**Consultation Response from KC,
 Lead Local Flood Authority**

2025/93438 Arena Young Peoples Centre, Moorlands Road, Dewsbury, WF13 2LF

Erection of 10-unit (class C2) special needs care home, day centre (class E(f), administration and training building (class E(g)(i)

Date Responded: 28/01/2026.

Drawing title: Drainage Strategy

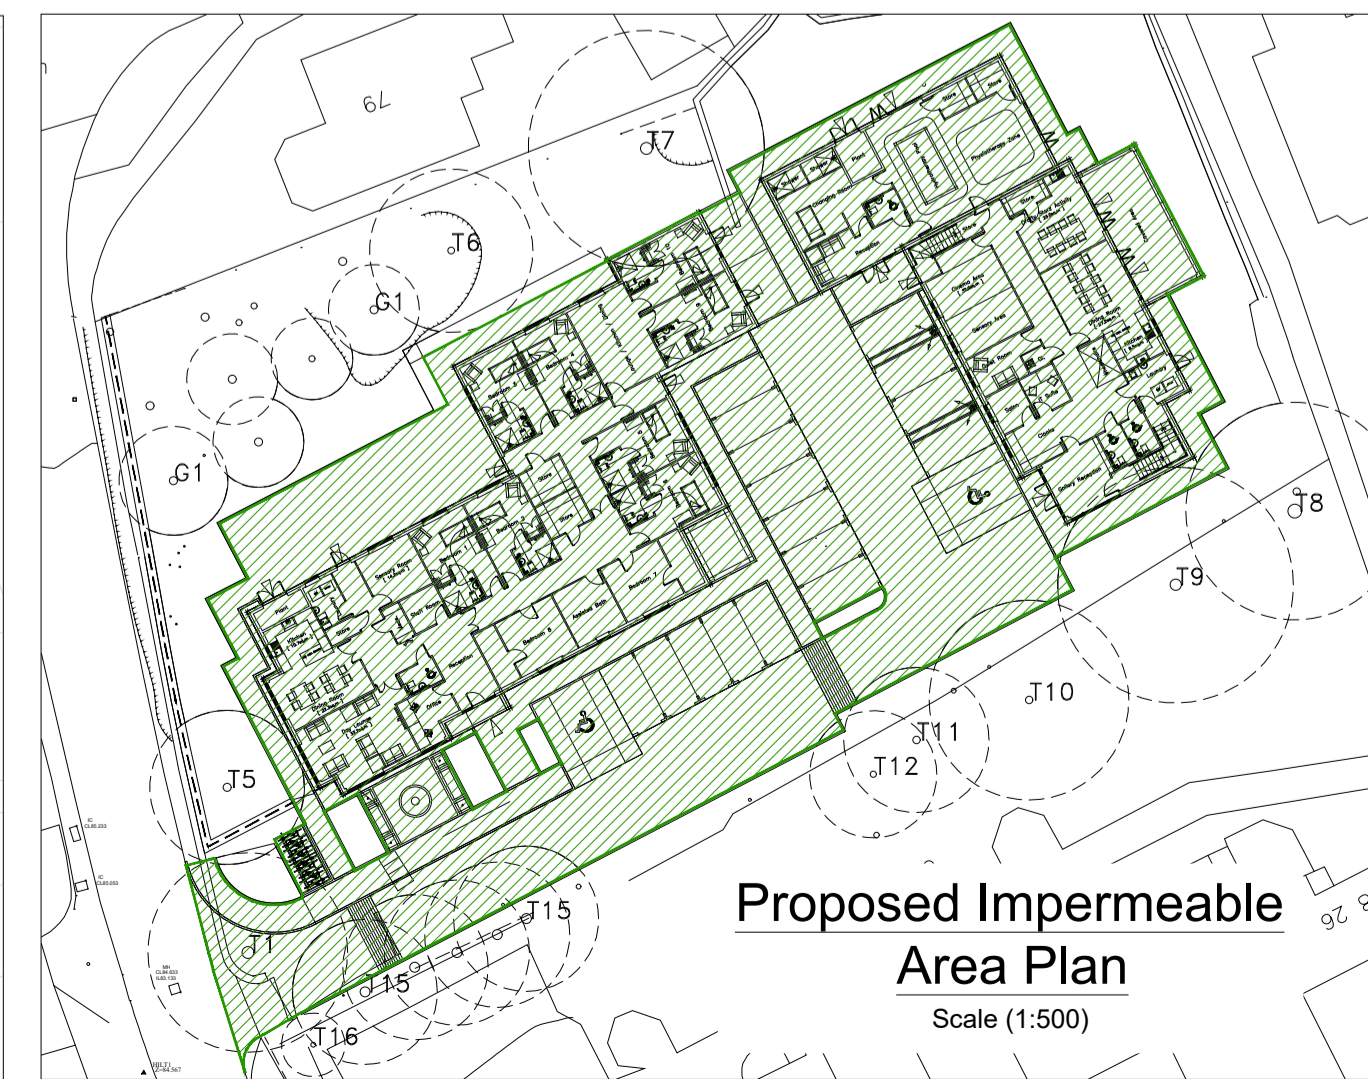
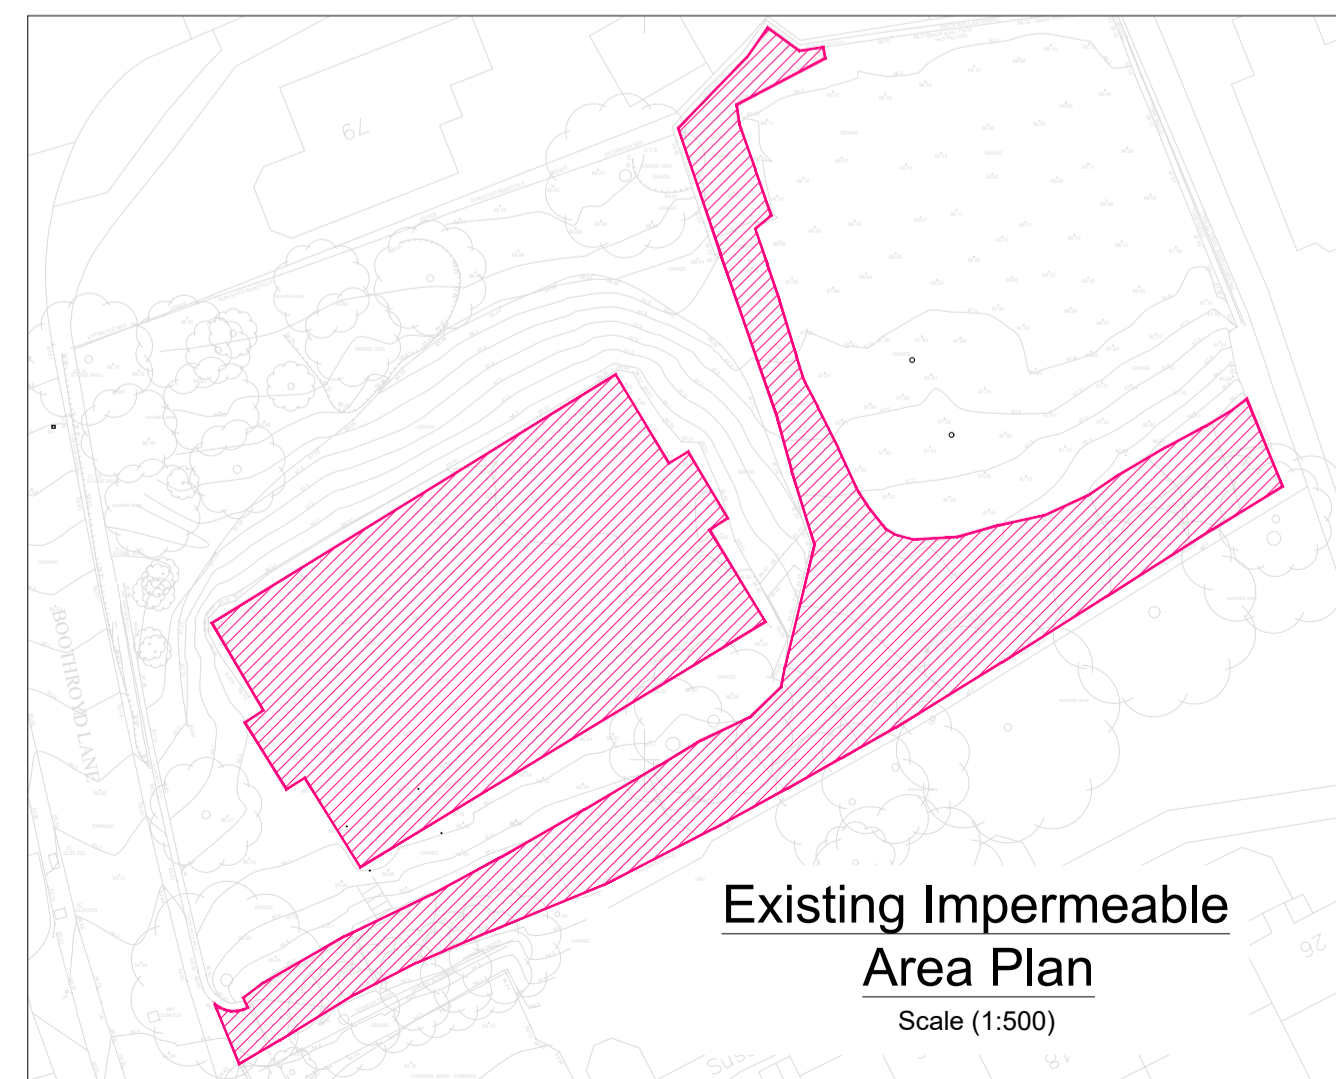
The LLFA confirms that soakaways are not feasible and therefore discharge of surface water run-off to the Yorkshire Water sewer network is acceptable at the proposed allowable discharge rate of 11.9l/s, **however** the discharge should be to the surface water sewer in Boothroyd Lane (which eventually connects to the river Calder). This connection would be subject to Yorkshire Water approval. A connection to the existing combined sewer outfall from the site as shown on the Drainage Strategy drawing would not usually be acceptable when there is a suitable alternative.
